Our Ref: 2023/92836

**TOWN AND COUNTRY PLANNING ACT 1990  
TOWN AND COUNTRY PLANNING (GENERAL PERMITTED DEVELOPMENT)  
(ENGLAND) ORDER 2015 (as amended), SCHEDULE 2, PART 3, PART MA  
NOTIFICATION OF PROPOSED CHANGE OF USE CLASS MA – COMMERCIAL,  
BUSINESS AND SERVICE USES TO DWELLINGHOUSES  
APPLICATION NUMBER: 2023/92836  
AT: 1st & 2nd floors, 9-13, Market Walk, Huddersfield, HD1 2QA**

**Prior approval of a proposed change of use of a building from commercial, business and service use to dwellinghouses**

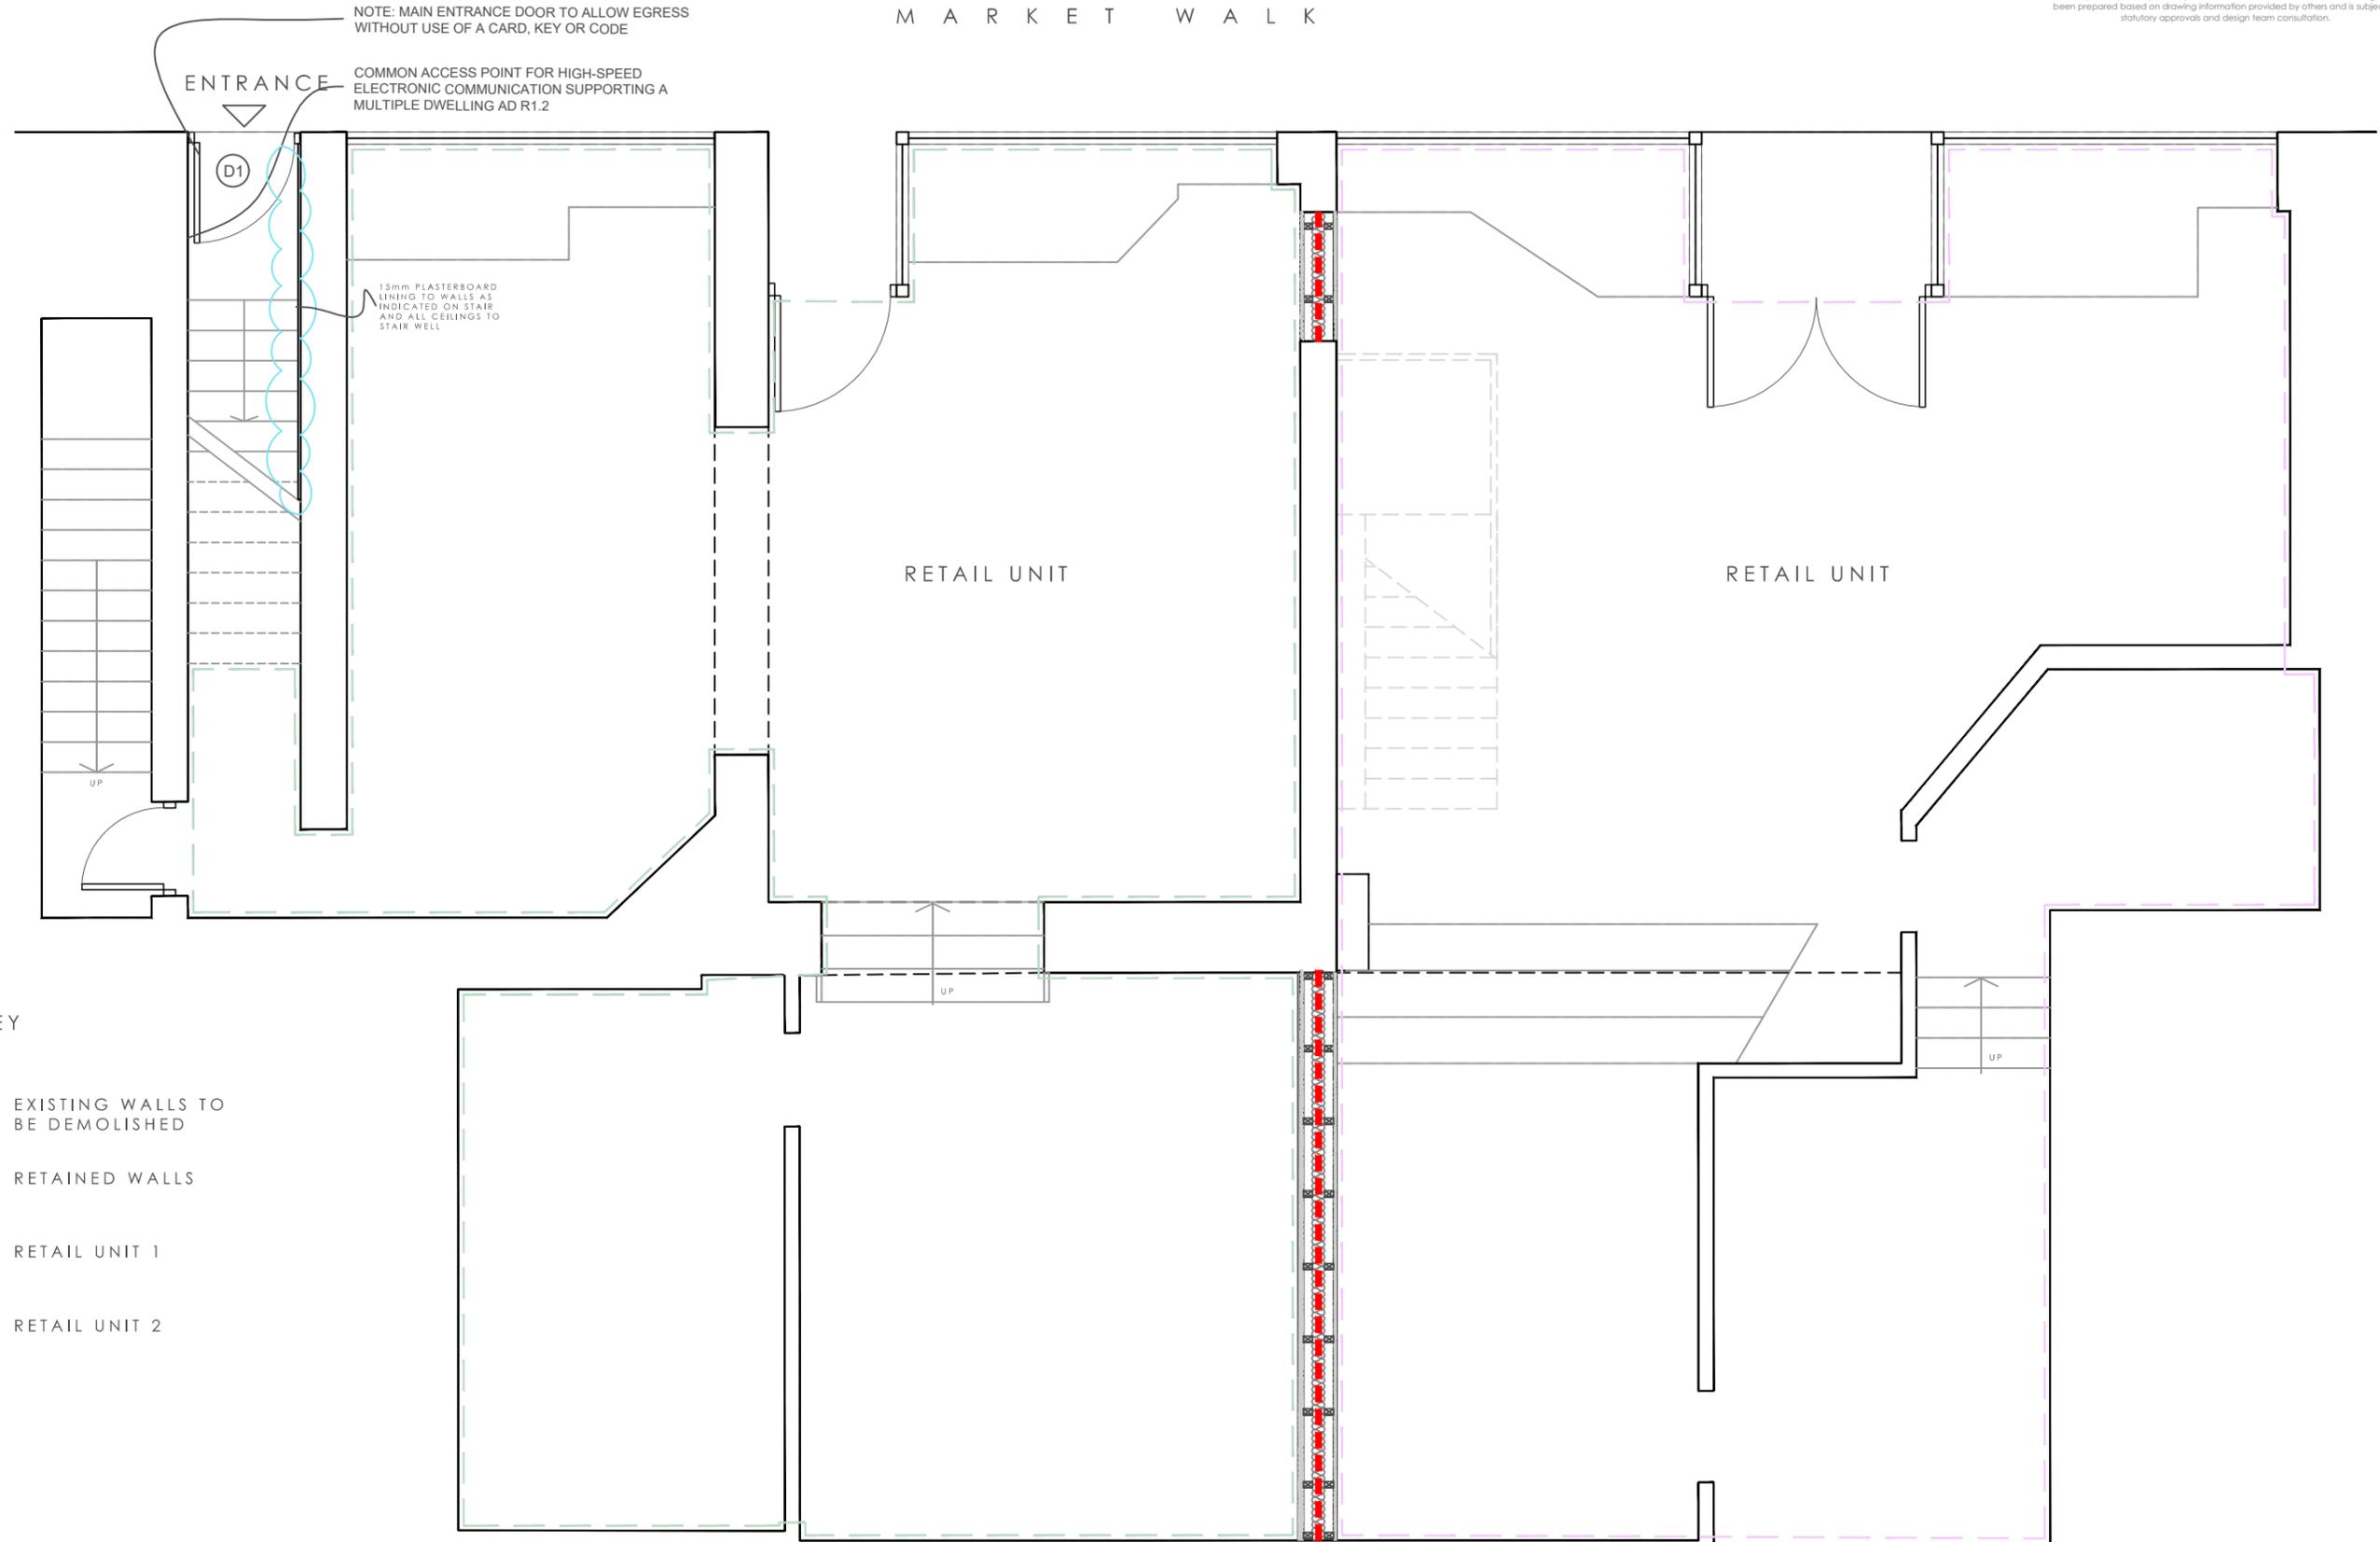
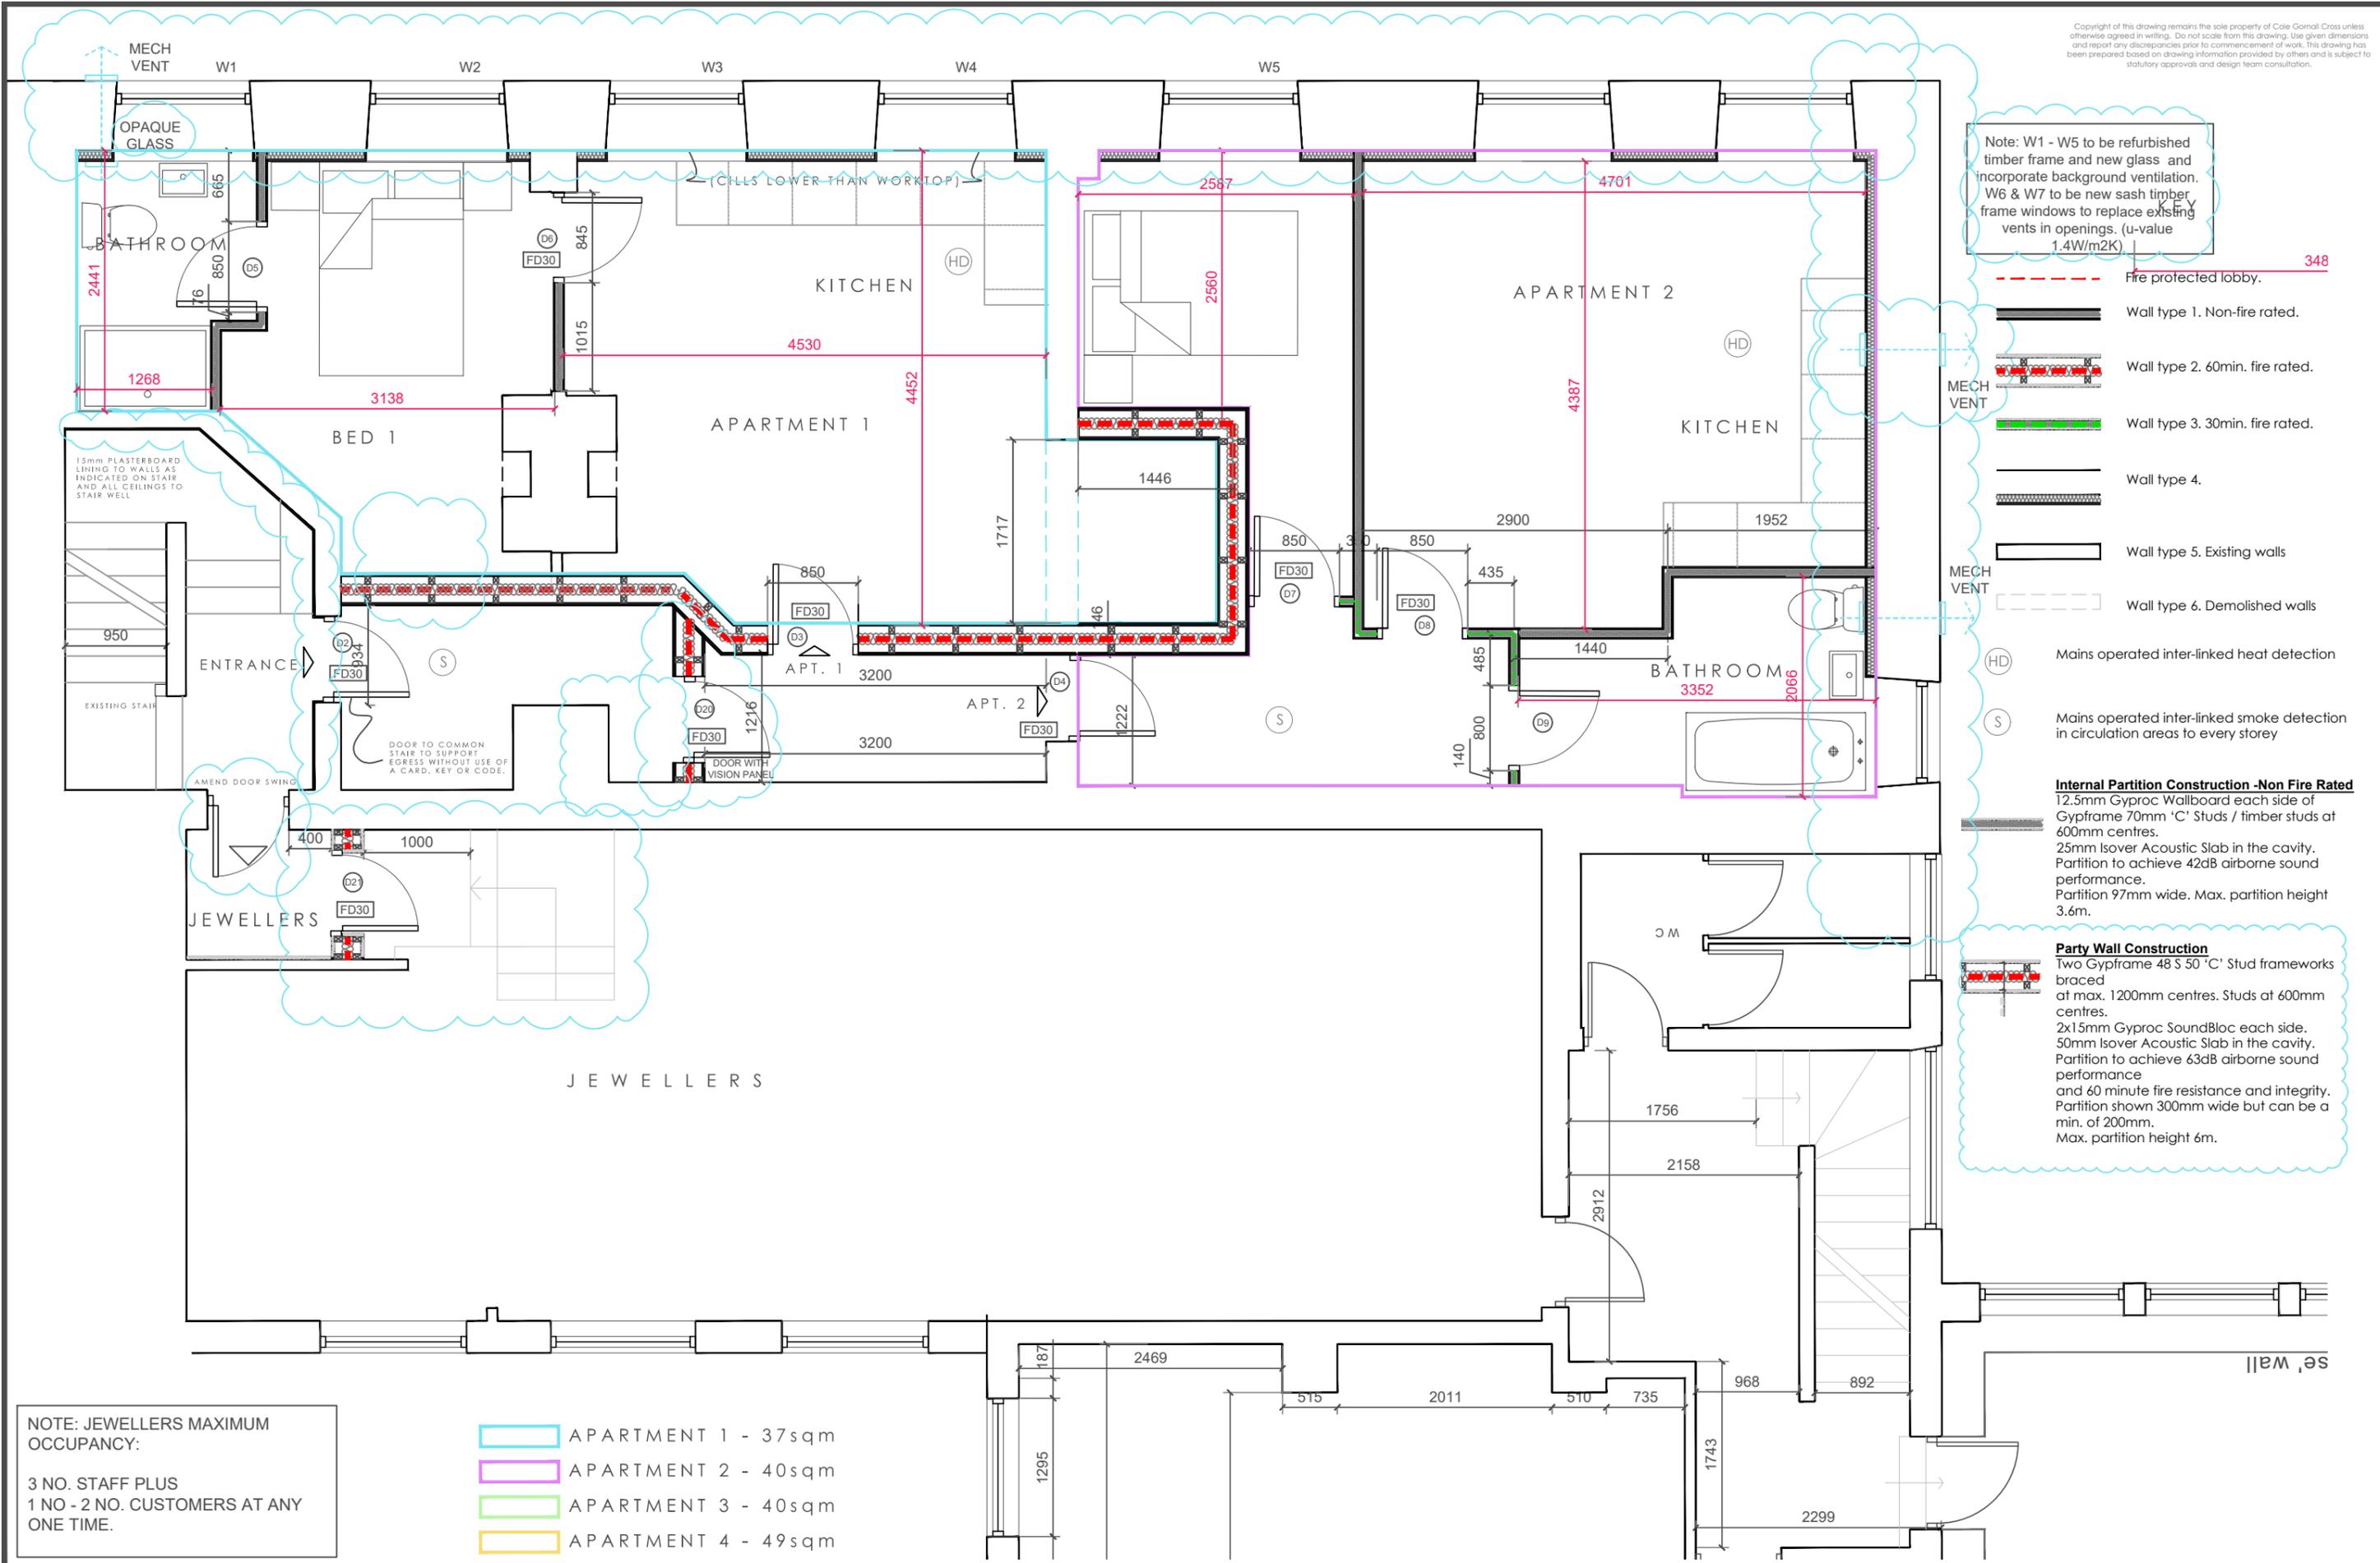
Apartment 1 is proposed to be a one bedroom first floor flat. The Technical Housing Standards document states that a one-bedroom flat for one person (minimum assessed) one storey should be at least 37 or 39 square metres dependant on whether the bathroom has a shower. In this instance, the internal accommodation is proposed to approximately 30.7 square metres which would not accord with the recommended space standards. However, the bedroom is shown to sleep two persons which requires 50 square metres of space, thus contrary to space standards.

Apartment 2 is proposed to be a one bedroom first floor flat. The Technical Housing Standards document states that a one-bedroom flat for one person (minimum assessed) one storey should be at least 37 or 39 square metres dependant on whether the bathroom has a shower. In this instance, the internal accommodation is proposed to approximately 34.6 square metres which would not accord with the recommended space standards. However, the bedroom is shown to sleep two persons which requires 50 square metres of space, thus contrary to space standards.
